Recommendation Report for Planning Permission for Works or Extension to a Dwelling

REF NO: BN/33/20/HH

LOCATION: The Garage Cottage
Church Lane
Barnham
PO22 0DB

PROPOSAL: Part two storey, part single storey side/rear extension and single storey rear extension.

DRAWING TITLE		PROPOSED PLANS AND ELEVATIONS	
DATE	SCALE	DRAWN BY GM	
Mar 2020	1:100@ A1	CHECKED BY	
JOB NO.	DRAWING NO.	REVISION	
2020-04	2.01

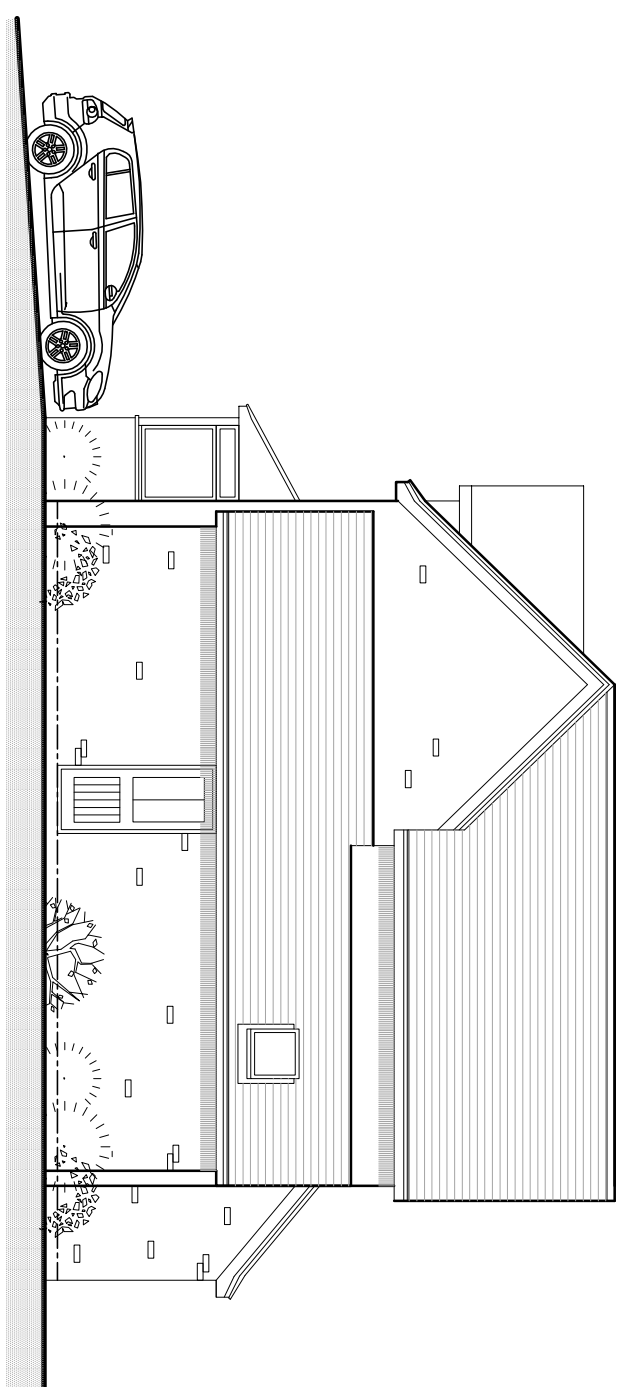
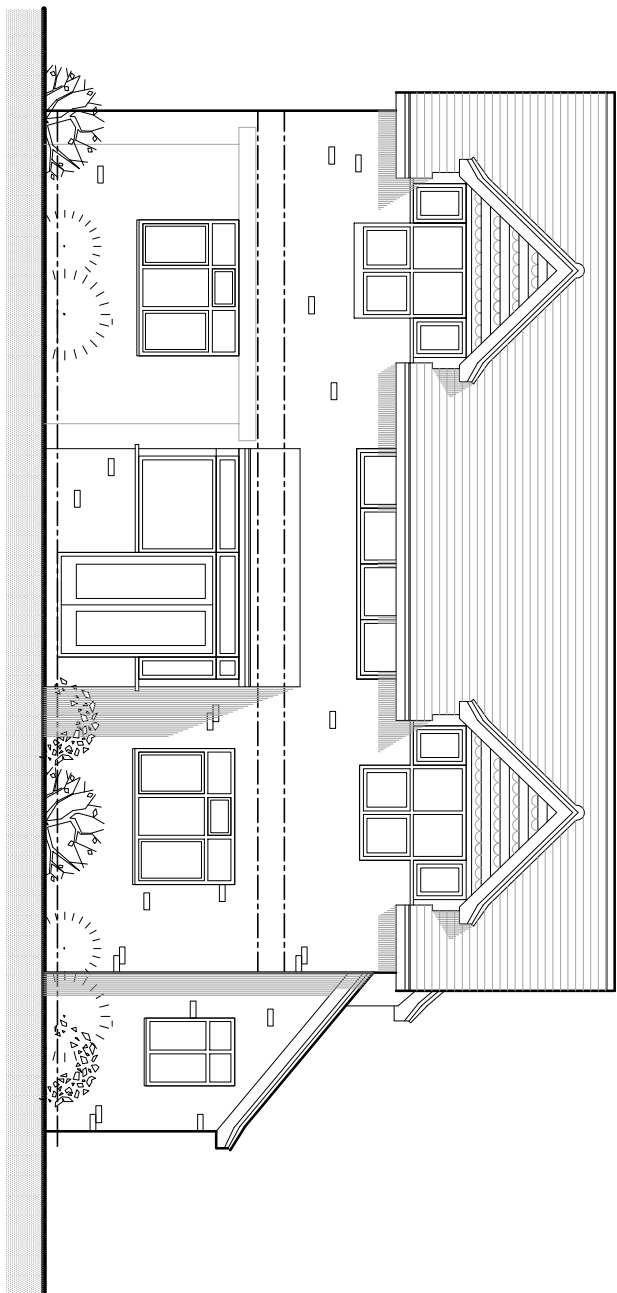
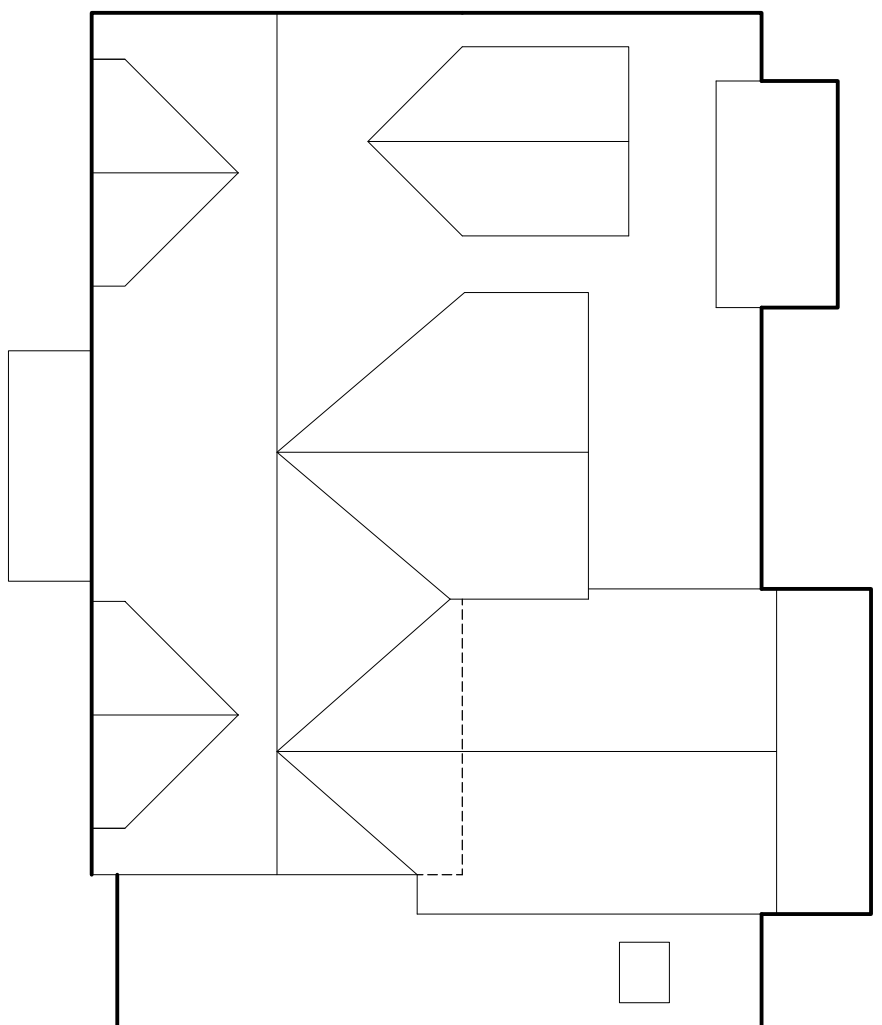
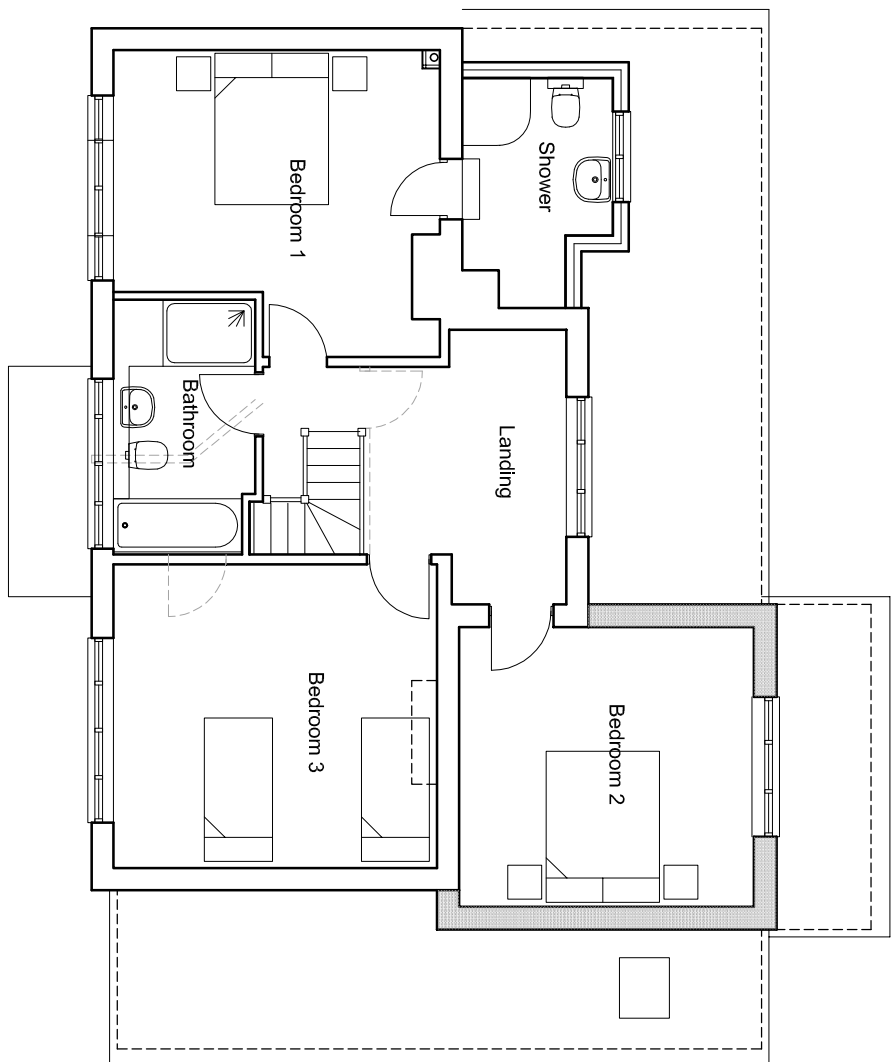
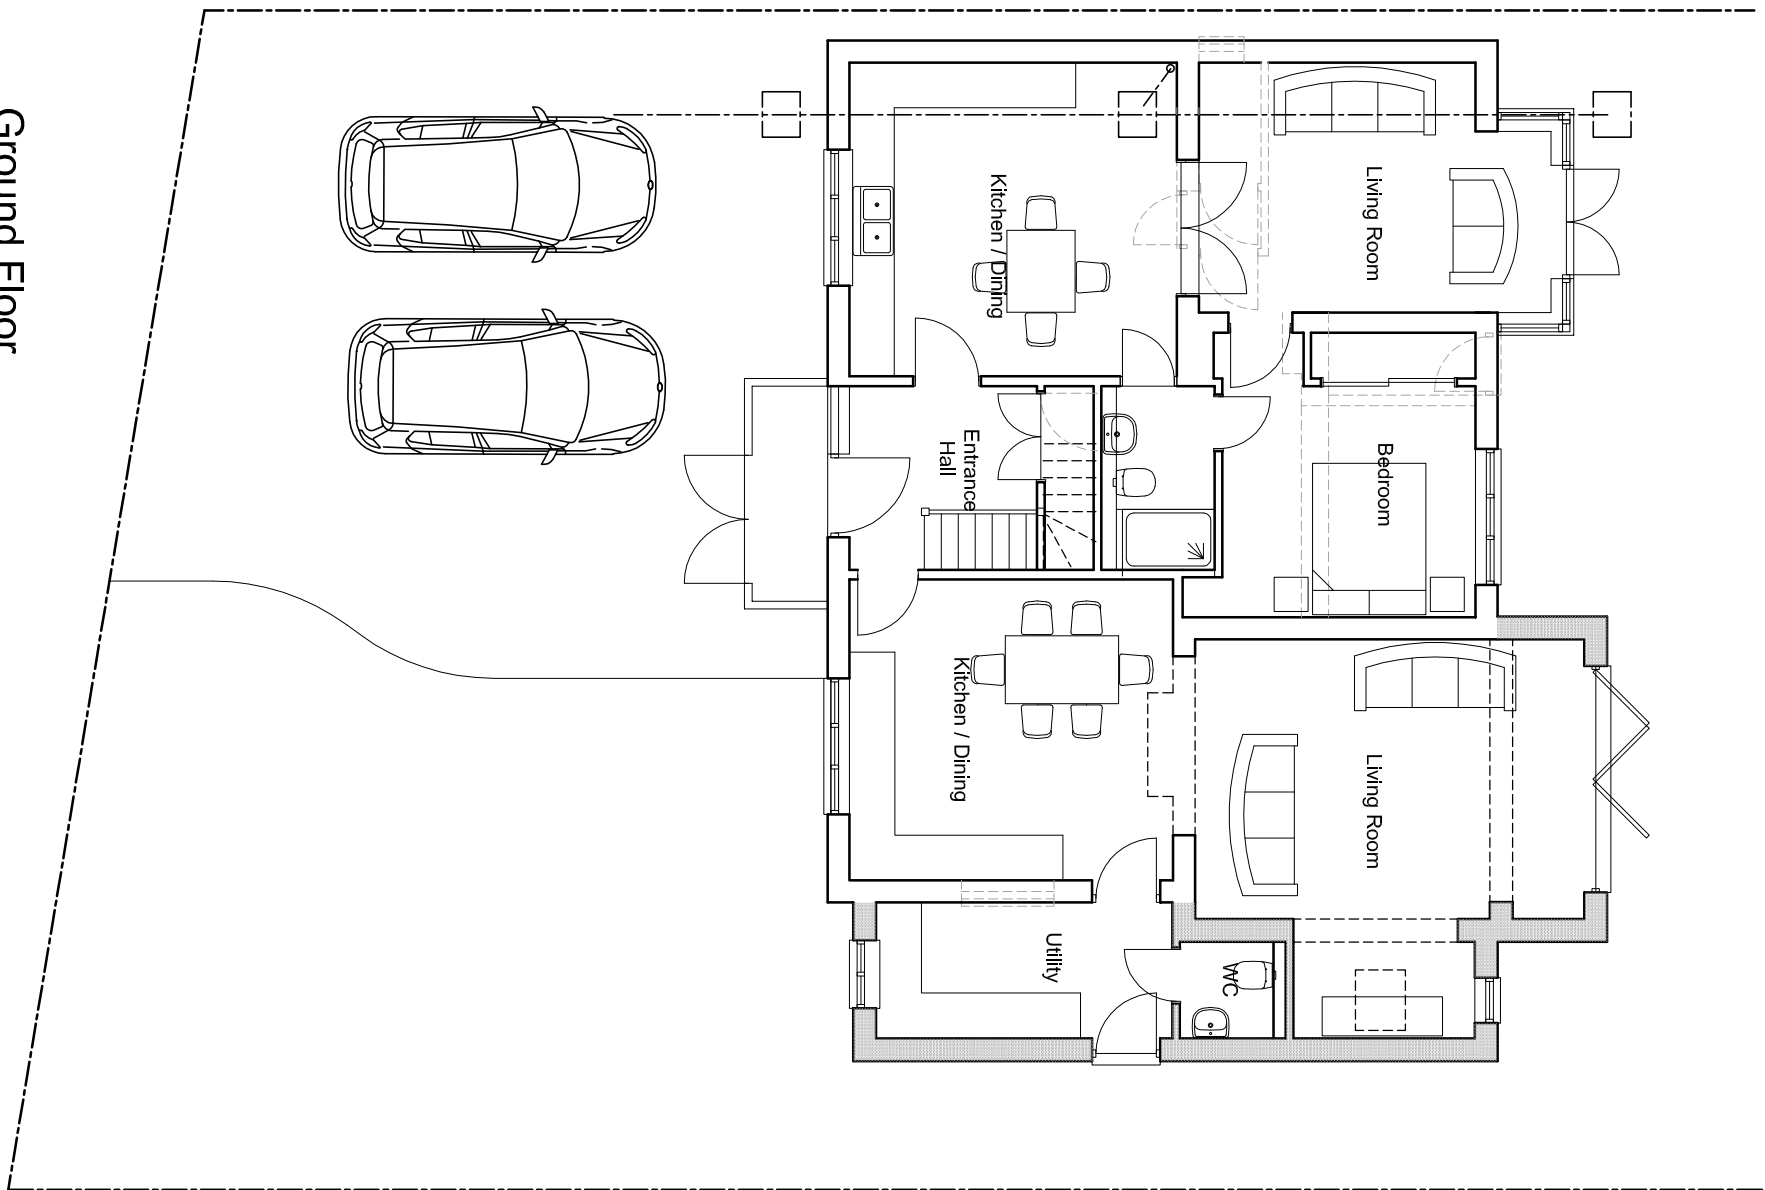
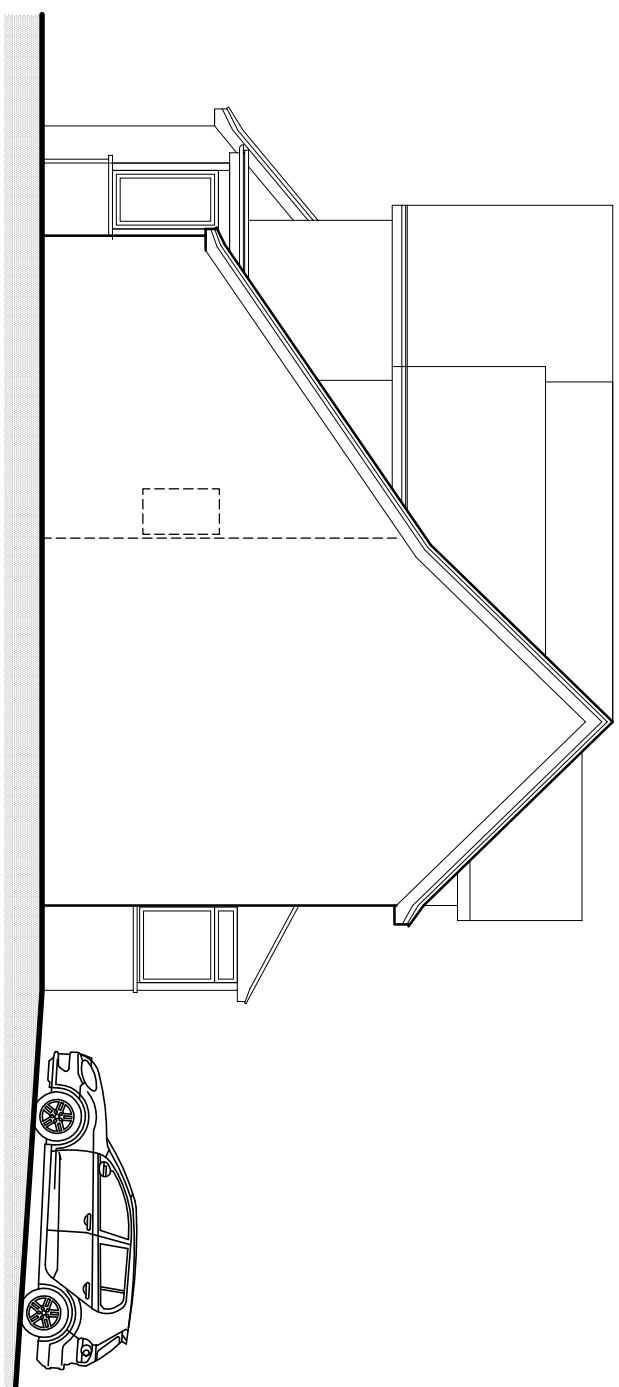
A single storey addition will run along the side elevation of the property and as such will be visible from the street scene. This has a lean to roof and is modest in size retaining 1.7m to the northern boundary.

The existing dwelling has 2 rear gable dormers with a cat slide roof. The two storey extension will be situated to the north west elevation and have a depth of 4.4m. This infills the north west of the dwelling meeting with the existing rear elevation. There will also be two single storey additions to the rear with a maximum depth of 1.5m.

The two storey extension will have a maximum depth of 4.4m to the north west elevation, this will then reduce to single storey for a further 1.5m. The ridge height and eaves will match that of the host dwelling. A single storey side extension will then run alongside the two storey addition with a width approximately 2m, with a lean to height of 3.75m. This retains around 1.7m to the boundary.

The single storey addition to the rear elevation to the western side, again it is modest in depth at around 1.5m. With a garage situated to the neighbouring property at 'Primrose House' and with 1.65m retained to this boundary, the single storey addition is not deemed to result in an adverse impact upon the neighbouring property.

There will be an additional window to the first floor rear and 2 to the ground floor however due to the siting, again is not considered to result in adverse overlooking. There will also be a door to the single storey lean to at the north, although again with no neighbouring properties is not deemed to give rise to overlooking.
